From: William Clark
To: Jean Fraser
CC: David Margolis-Pineo; Jennifer Thompson
Date: 10/22/2015 2:22 PM
Subject: Re: Fwd: 415 Subdivision Plat for PB - signoffs needed (2015-162) - Plan Needs Attention
Attachments: Cumberland Ave No 415 Draft Plat 10.14.15 Survey Review 10 22 2015.PDF

Examination of plan and deeds shows it needs attention and should not be approved. Plan review markup is attached. I am glad Jen made comments as to the easements.

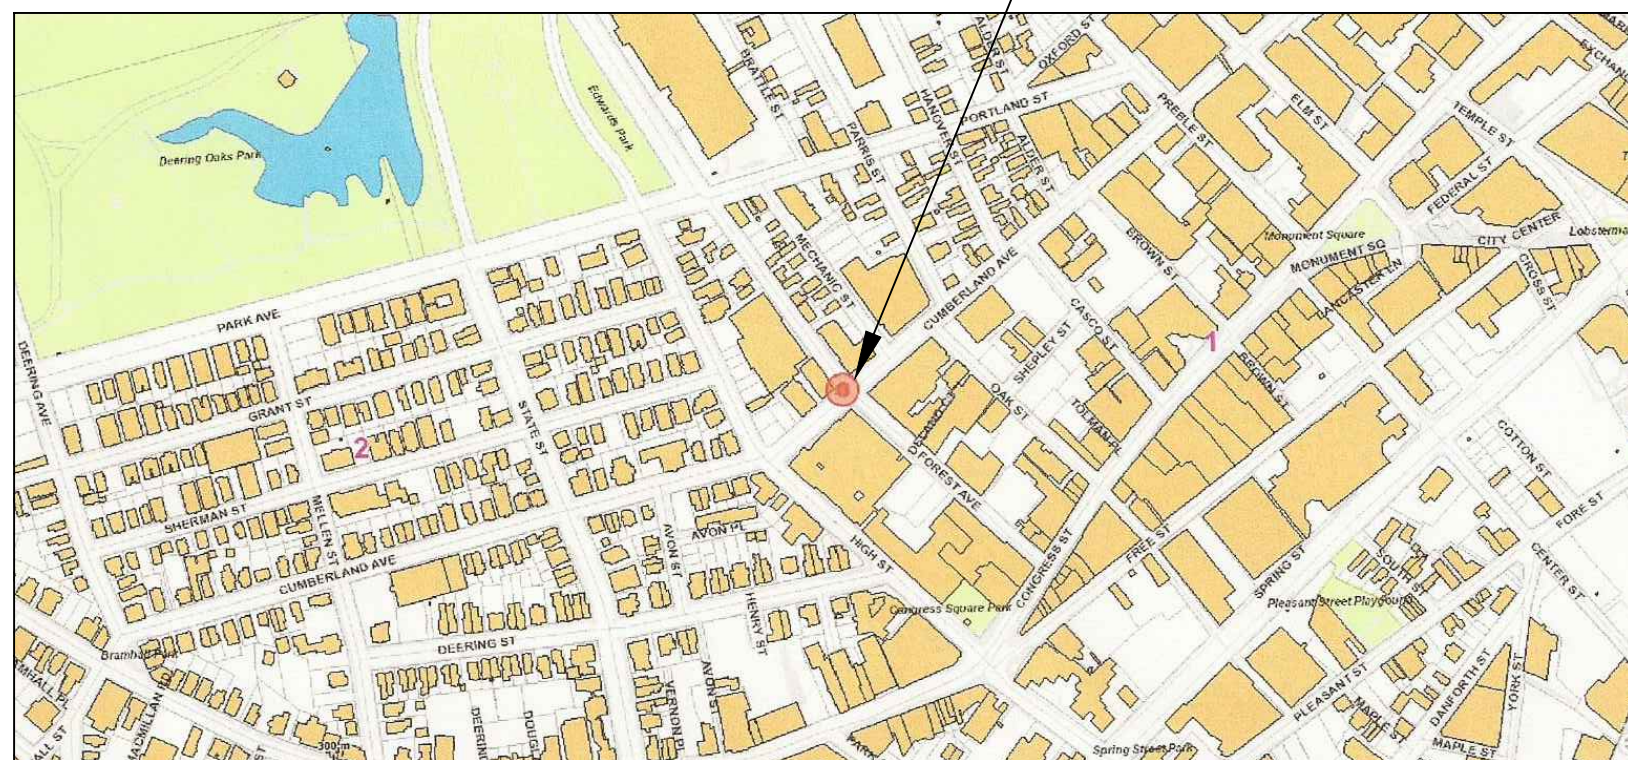
1. Easements need to be correctly defined on the plan with bearings and distances. The easements were drafted in 1925 before the YMCA building was constructed, and need to reflect what is on the ground. The Condominium Association will need to have the easements defined and the nature of the easements stated.

2. Incorrect Easement Deed Reference. CCRD Deed Book 3019, Page 133 is for a Tax Lien Discharge in Cumberland , Maine.
3. Text "Existing Easement Area book 1212, Page 217" points to the easement area for easement in Deed Book 1212, Page 215.

4. Coordinates are not correct for the two points listed along Forest Ave.
5. Elevations are not correct for the two points listed along Forest Ave.
6. Need to set property corners.

7. Coordinate System. NAD83?
The City of Portland coordinate system is NAD83 HARN Maine State Plane: West Zone (FIPS 1802) US Survey Feet
8. Vertical Datum. Which City of Portland official benchmark was used?

9. "Lotus Map". I believe this should be "Locus Map".
